Response to Planning Application

From: Arun District Council Greenspace

Application ref: A/109/20/RES

Location: Land South of Water Lane Angmering

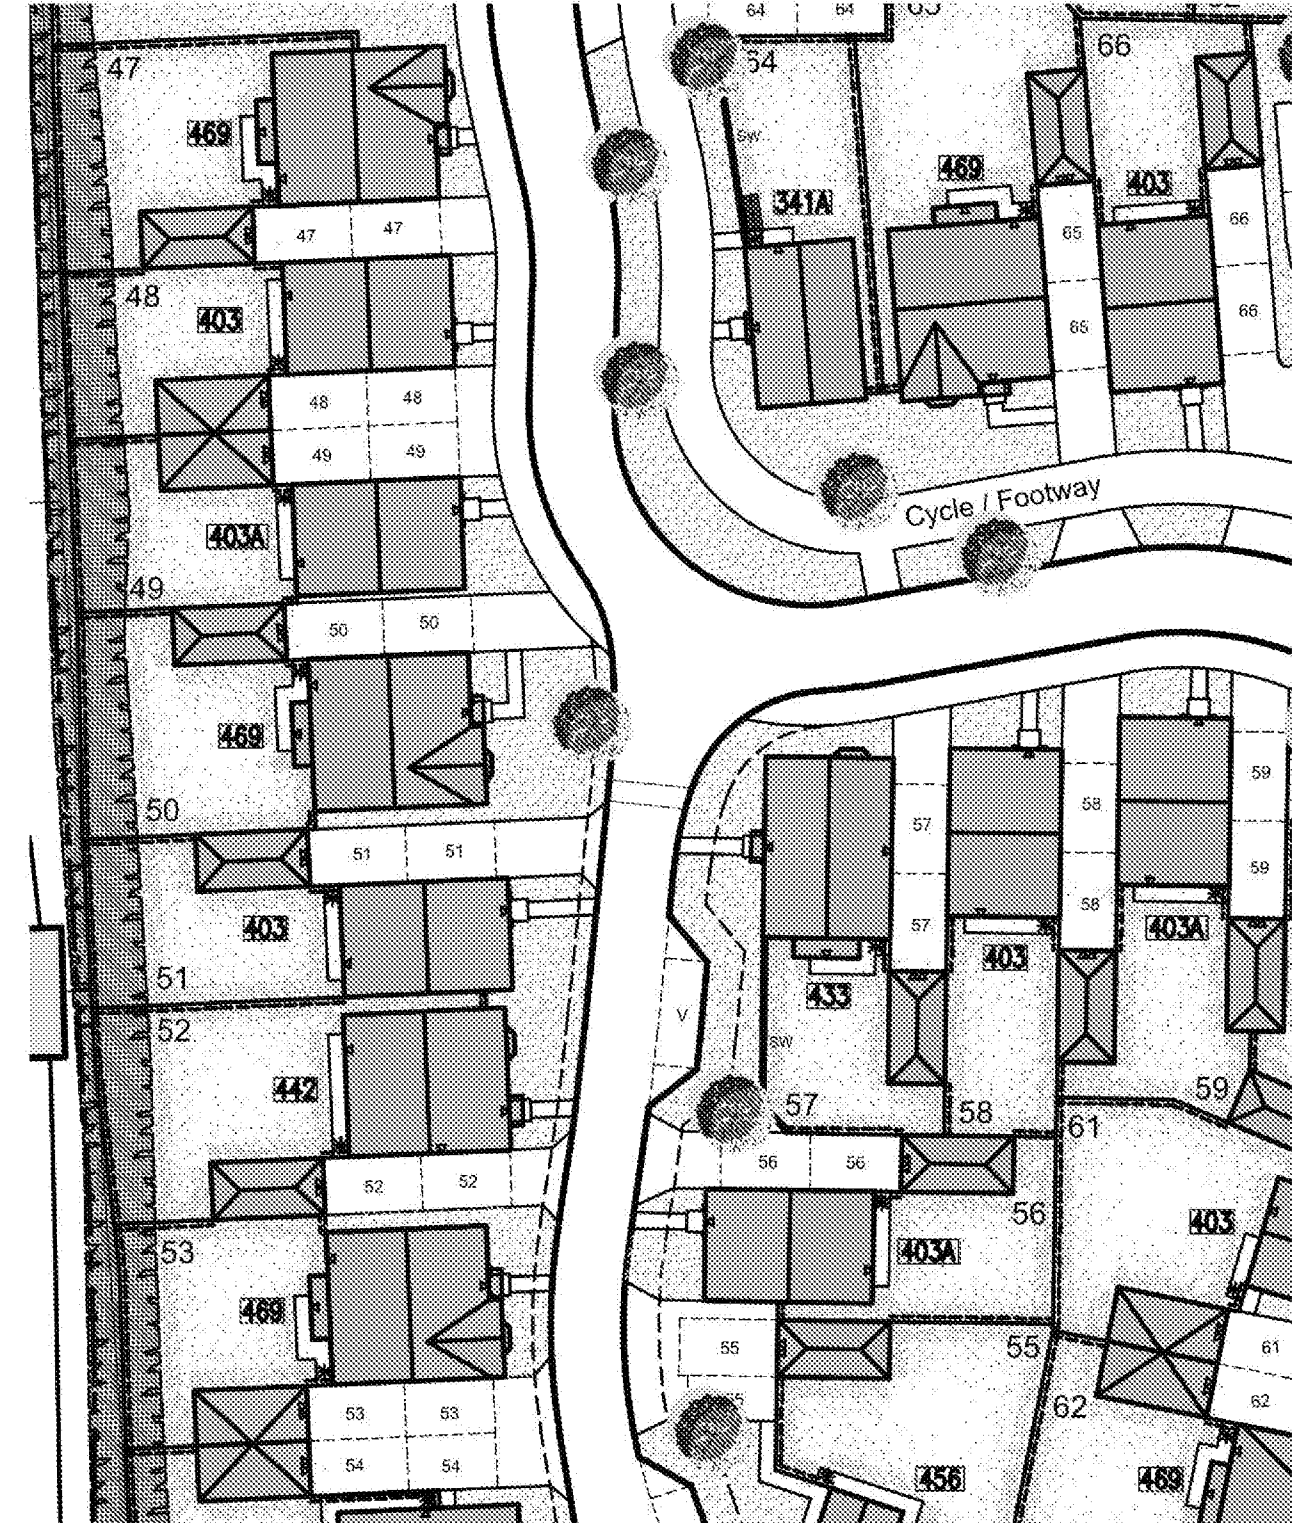
- The illustrative masterplan previously approved Dwg 1911/P 03 Rev L detailed a far greater amount of tree planting particularly to the sites main spine road. Many trees were shown forming an avenue along this roadway on both sides of the road. This feature would appear to have been lost with the detailed plans which now show predominantly trees to the west of this roadway and in much fewer quantity. Whilst trees need space to establish and thrive and not just be crammed into planting pockets, **I would like to see this tree lined feature reinstated into the detailed plans as shown and agreed at outline stage.**
